App No 3/2025/0720

Proposal Proposed demolition of existing holiday let chalet and replacement with one single-storey two-bedroom holiday-let. Alterations to existing access and with replacement entrance gates and fencing and creation of parking area.

Location Hazelmere Longridge Road Hurst Green BB7 9QP

Kelly Holt
Highways and Transport
Lancashire County Council

DRAWING TITLE:
 Proposed Entrance Elevation

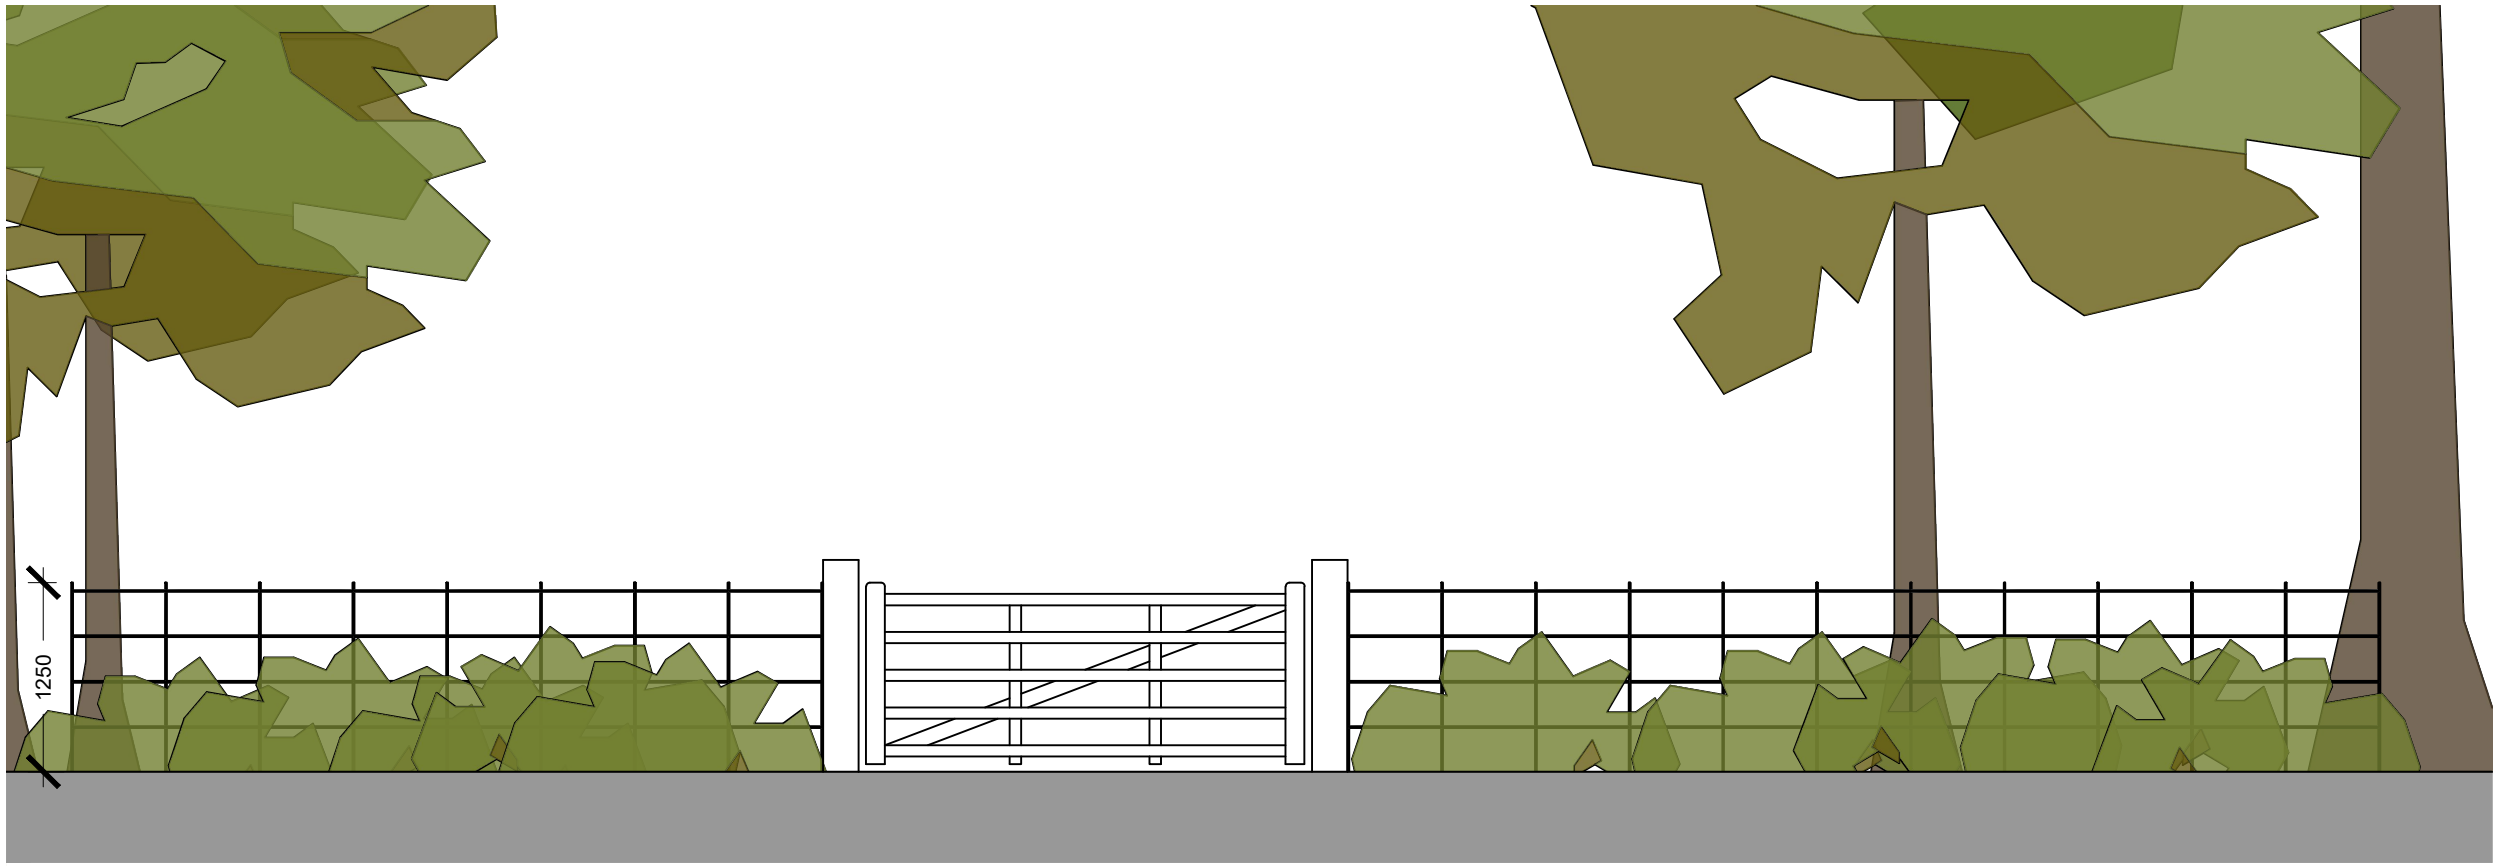
The site access is proposed at a width of 3m, previously 4m. We would recommend that the access site is widened to 4m for the first 5m at least, to the west side of the access and with the radius widened to 6m to allow vehicles entering the site from the west to easily transition into the access from the 40mph speed limit classified road for highway safety reasons.

The gates are set back by 5.6m and this is considered acceptable. The site access for at least the first 5m should be paved in a bound and porous material. The surface water is proposed to be drained and outfall to the Bailey Brook. The applicant should ensure that they have a permit for the drainage works.

2. Prior to commencement a scheme for the site access (4m wide, paved and drained) shall be submitted and approved by the LPA (see informative note).
Reason: For highway safety.
